23 October 2012

Our ref: JS/12-197

re: SSD-4972, Four Points By Sheraton Hotel Expansion

DEC 21 12PM

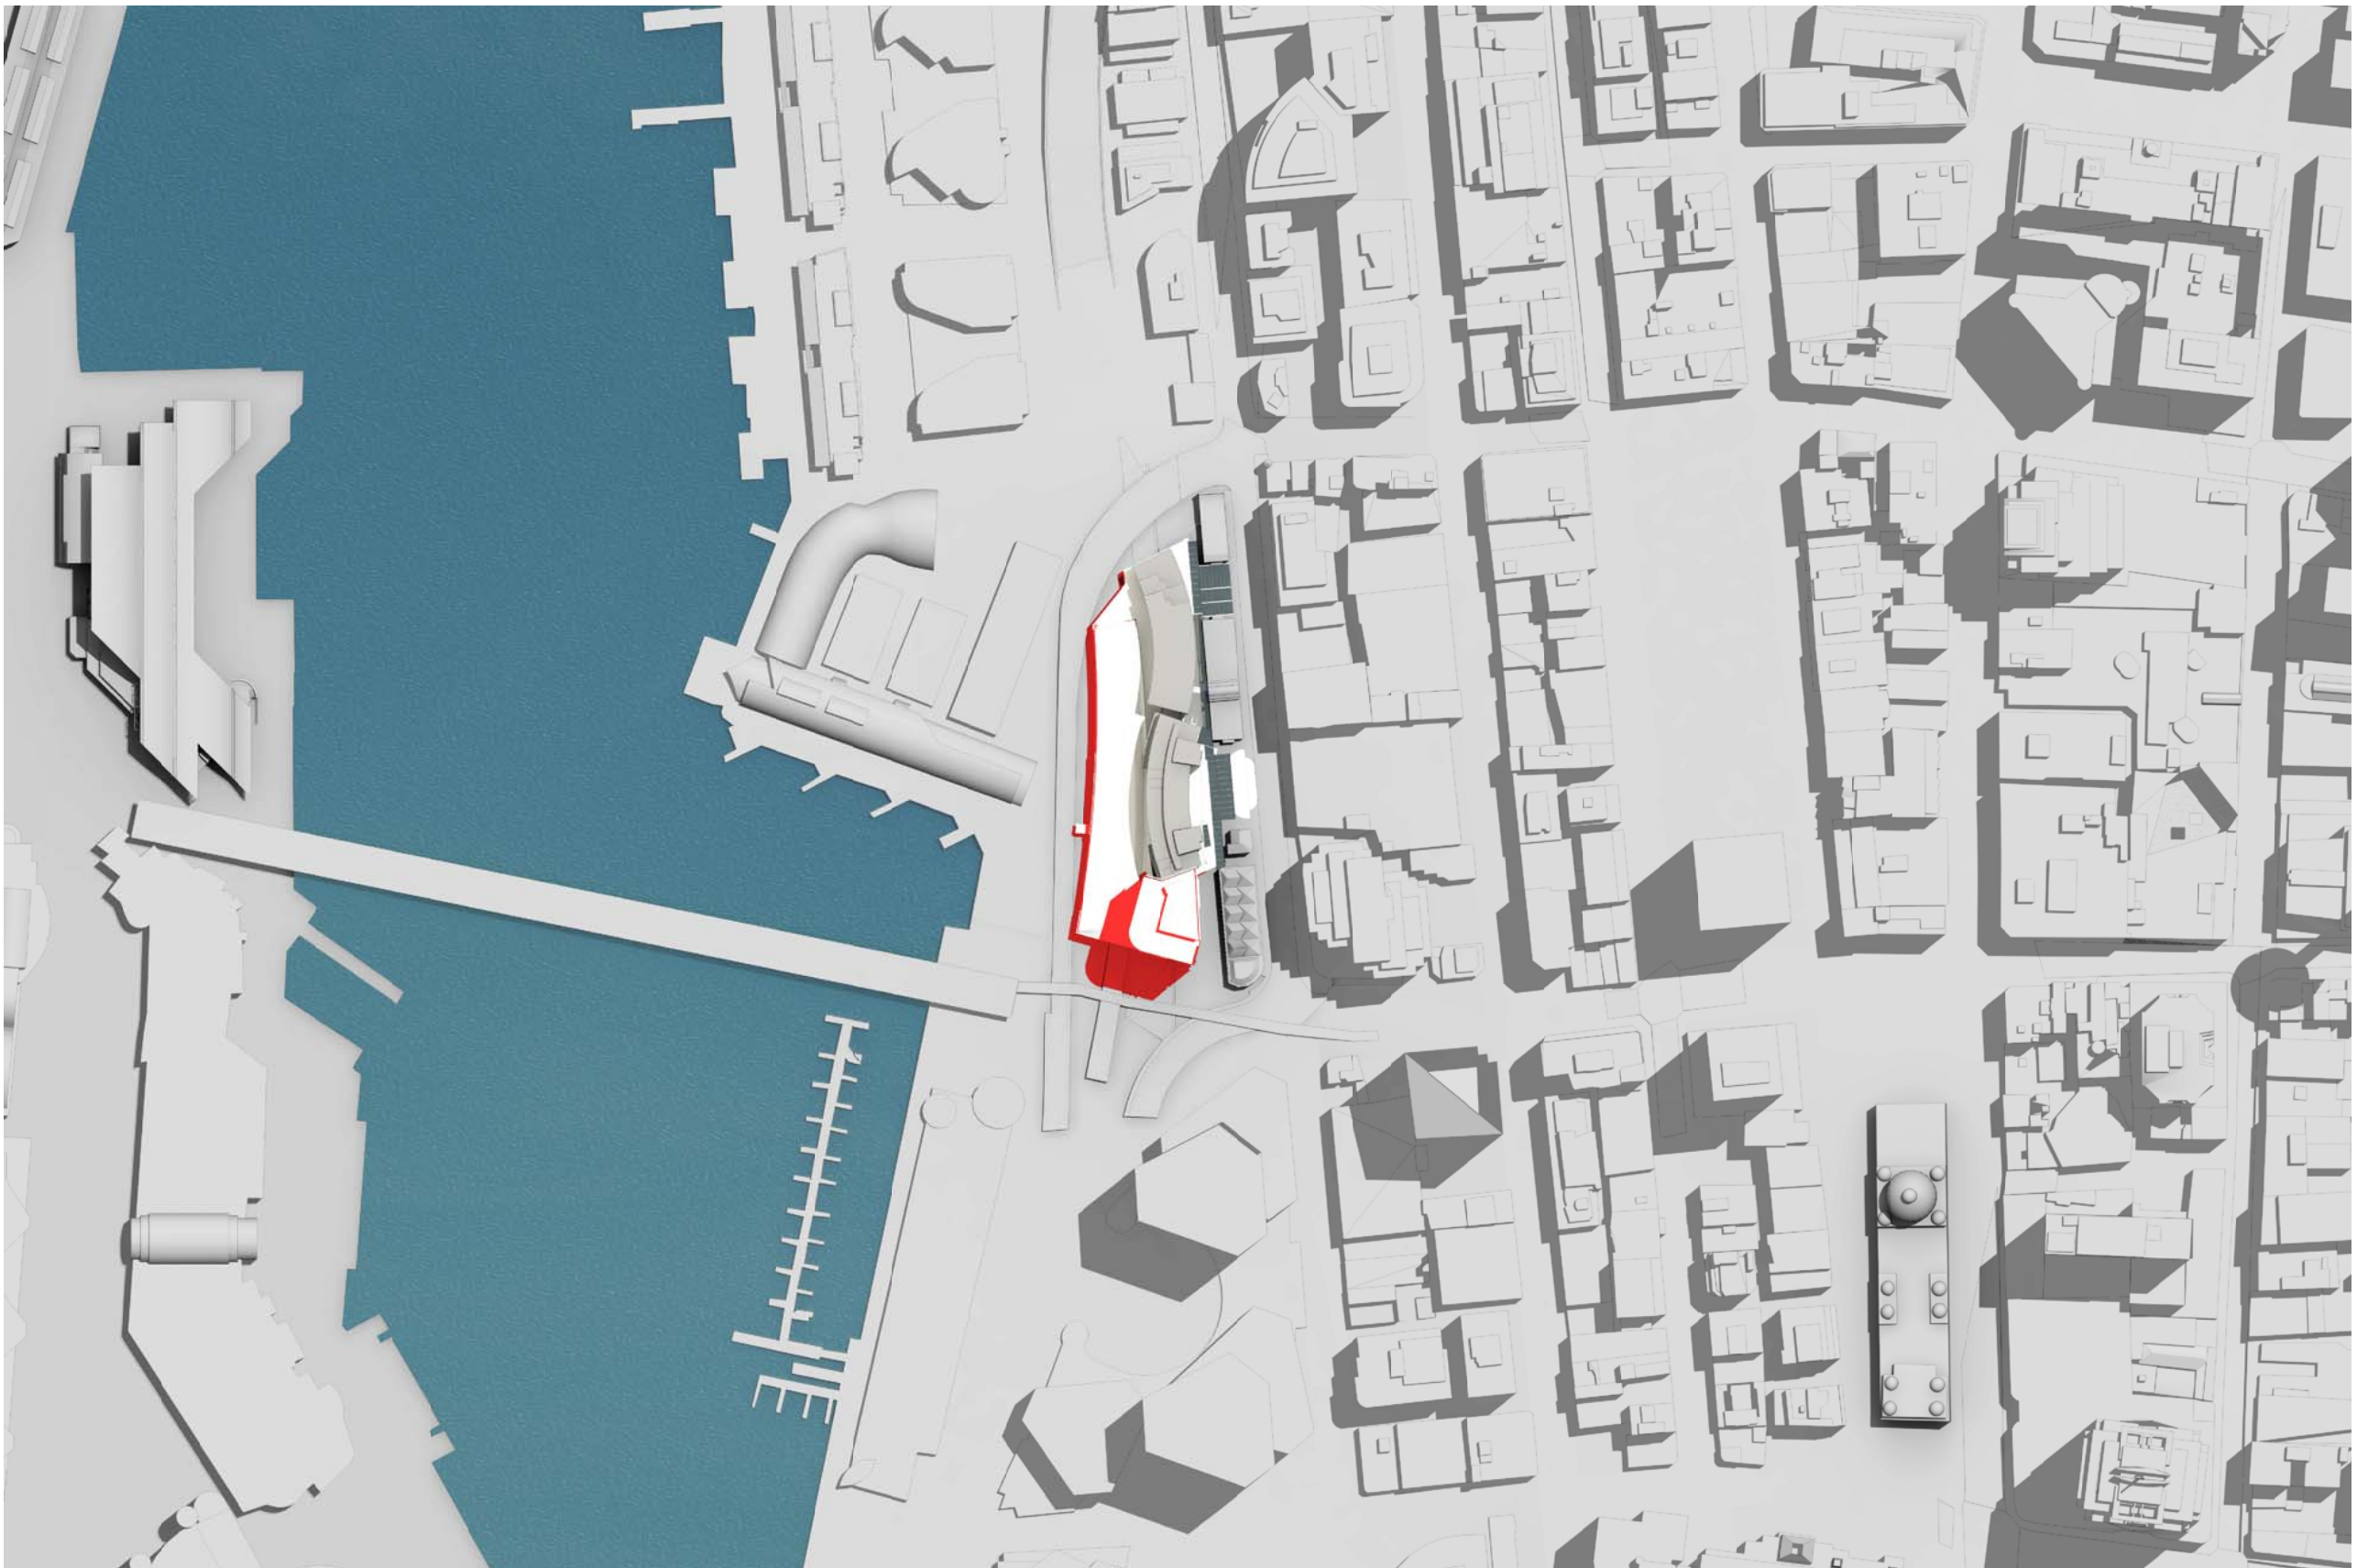
- The shadow diagrams placed on public exhibition with the State Significant Development Application are unclear. Our client should be provided with shadow diagrams, prepared on an hourly basis on June 21 (between 9am and 3pm) in both plan and elevation form to detail the overshadowing impacts from the proposed development on the forecourt (in front of the CBA tower) and on the CBA Tower itself;
- Location of cranes, Noise, Vibration and Air Quality – the proponent has stated that they will prepare a construction management plan. Our client would like to have some input into this plan – prior to the approval being implemented; and
- Traffic and Parking – the proponent has stated that they will prepare a construction traffic management plan. Our client would like to have some input into this plan – prior to the approval being implemented.
